May 13, 2016

Re: Taco Bell Renovations

4815 4th St NW

Request for Permanent C.O. - Accepted Engineer's Stamp dated: 8-26-15 (F14D071)

C-101

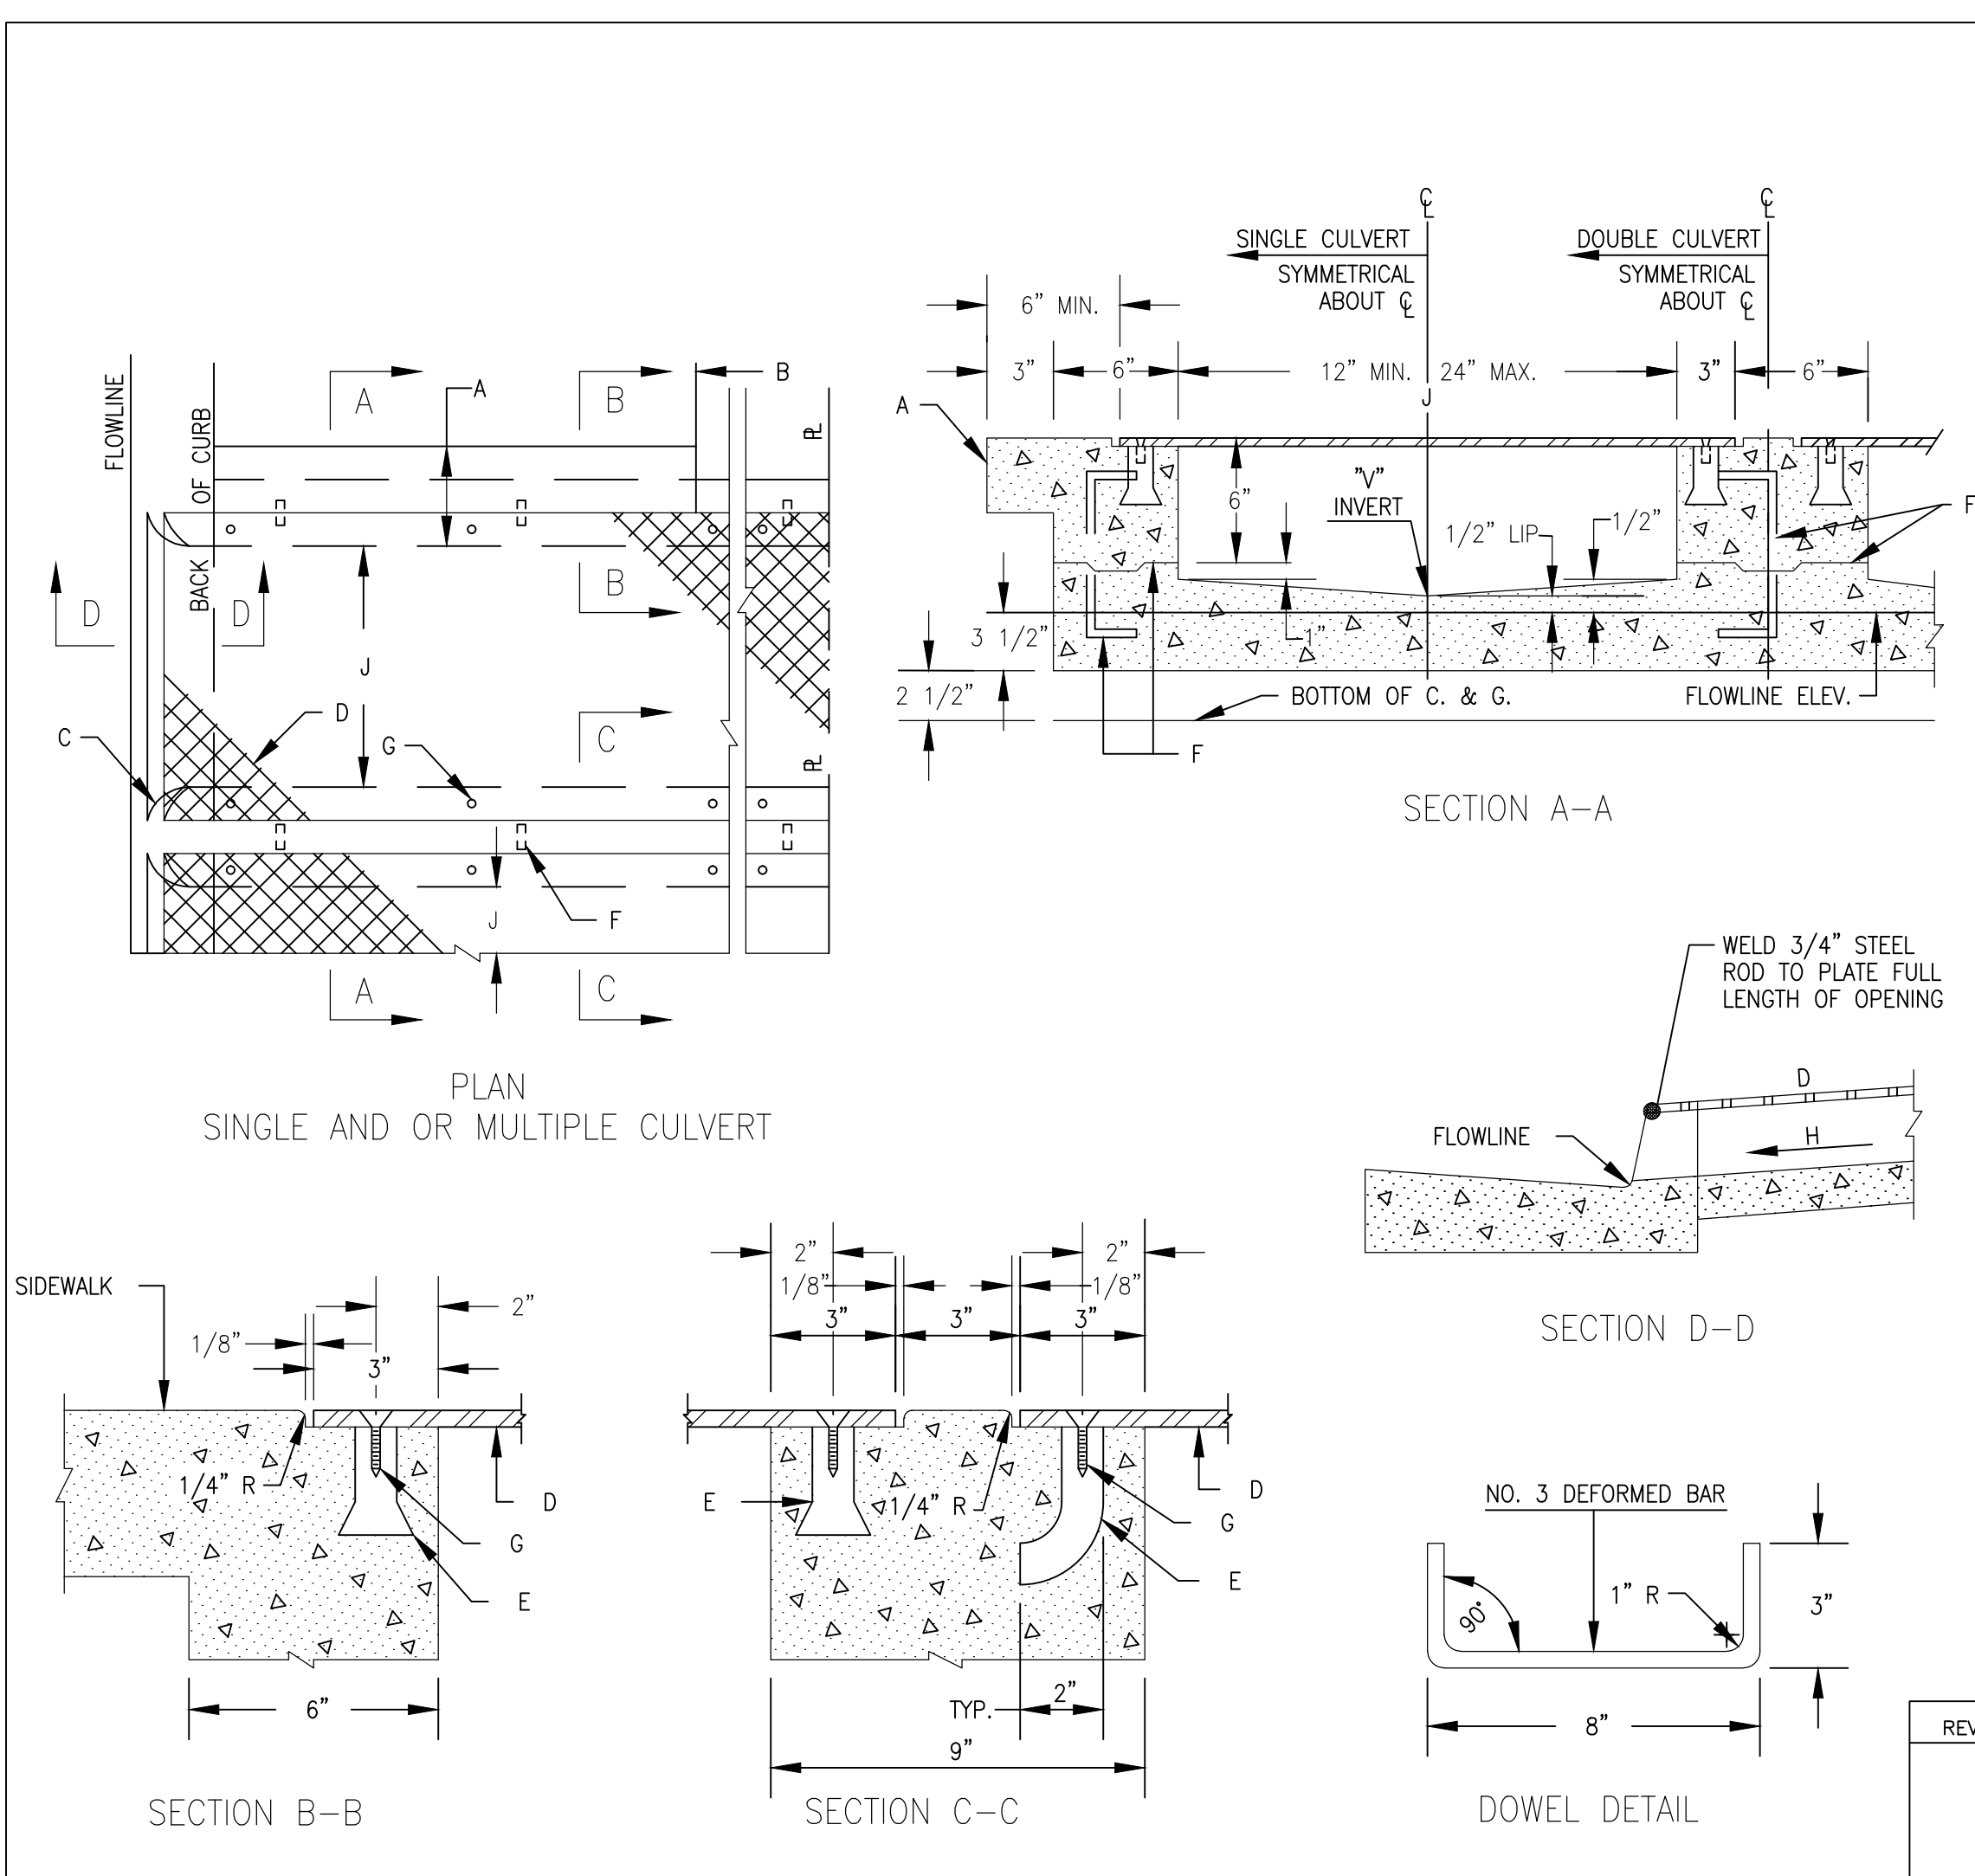
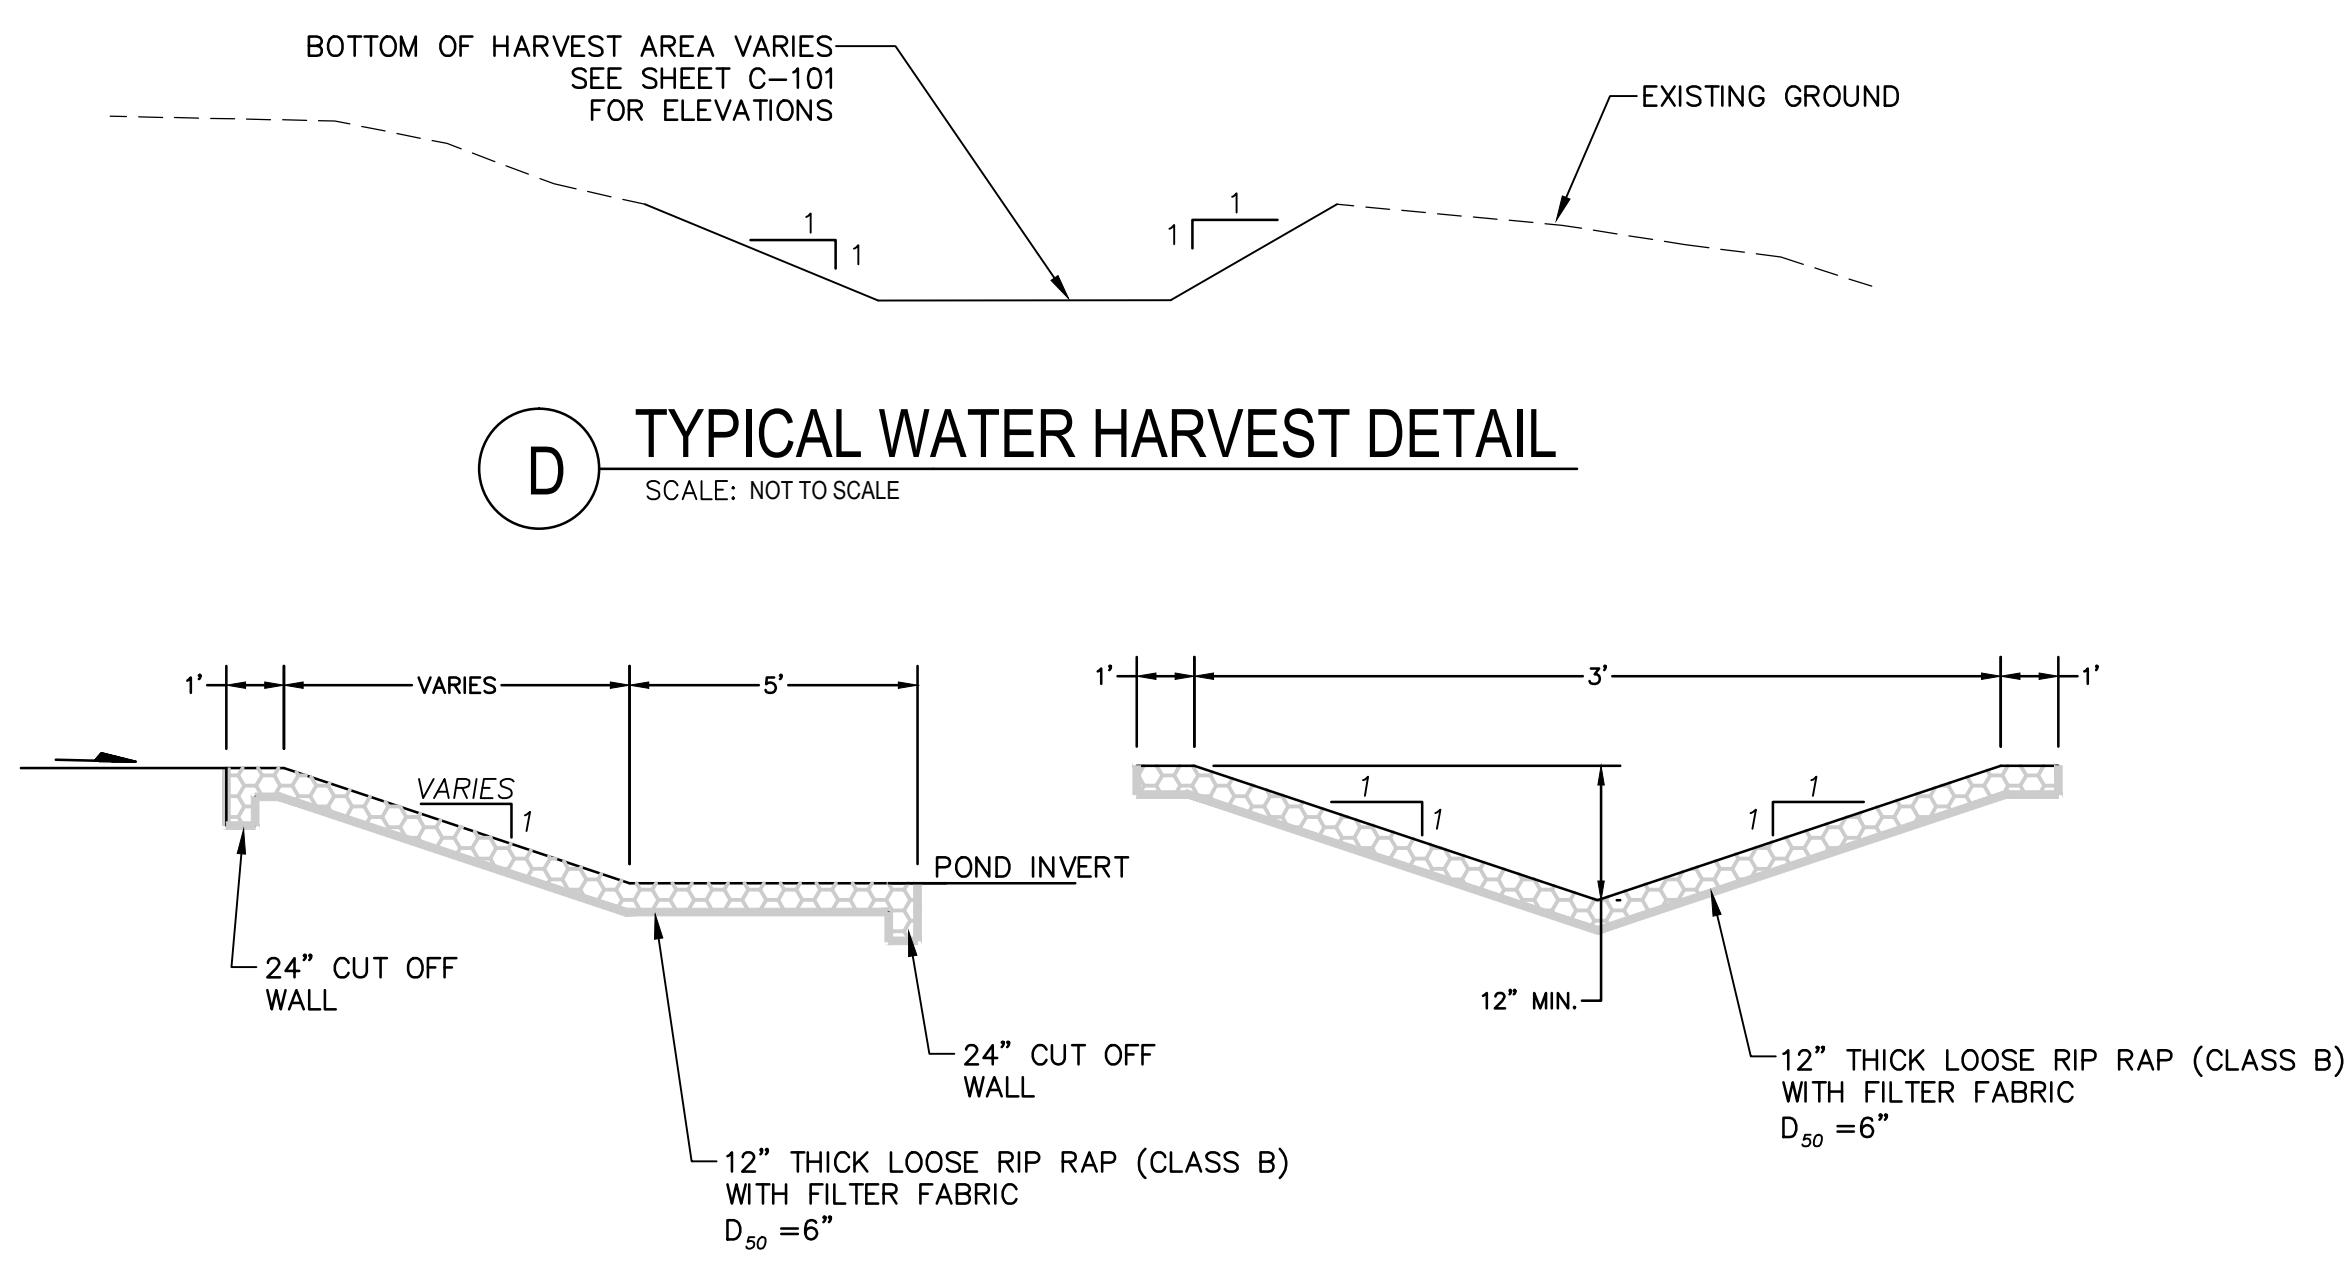
• The sidewalk culvert must be completed. Until it is complete it must remain barricaded with "Sidewalk Closed" signs on both sides starting at each entrance to the site. The bottom of water harvest on this pond needs to be approximately 3'-3" below TOC.

The pond that diverts to the above mention culvert needs to be graded to flow into the culvert.

The bottom of water harvest on the NW corner needs to be approximately 3'-3" below TOC.

The 3' curb cut is missing from this water harvest area.

The bottom of water harvest on the SE corner needs to be approximately 2'-3" below TOC.

The bottom of water harvest on the east side needs to be approximately 2'3" below
